AB/52/22/PL

2-4 Arundel Post Office and Delivery Office High Street Arundel BN18 9AA

Replacement boiler flue. This application affects the setting of a Listed Building, may affect the character and appearance of the Arundel Conservation area and is in CIL Zone 2 (zero rated) as other development.

Existing stainless steel boiler flue to be removed and replaced.

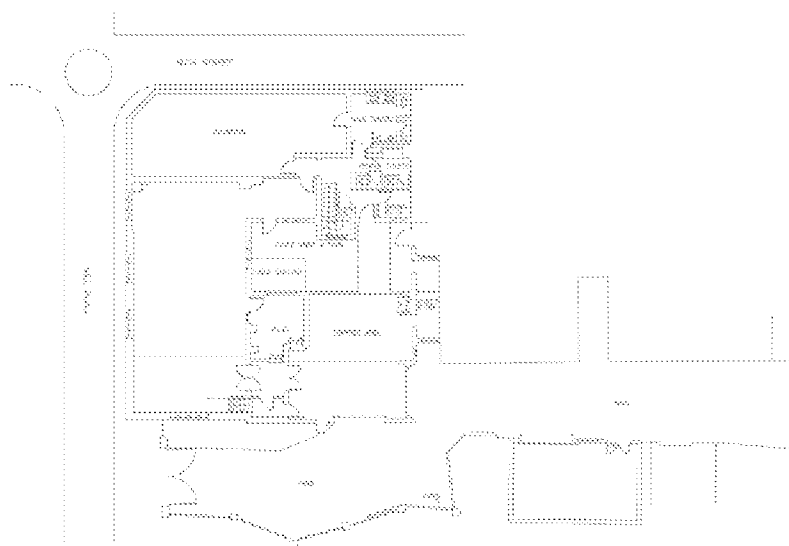
The proposal is for a replacement boiler flue. This flue would be larger than existing, but it is noted that this is required in order to meet current code/regulations. The location of the flue is such that it would not be clearly visible from the road to the front or the area of open space to the side, and therefore not cause harm. It would appear that the flue would be a black colour, but it is recommended that if this is not the case that it should be a requirement of any consent.
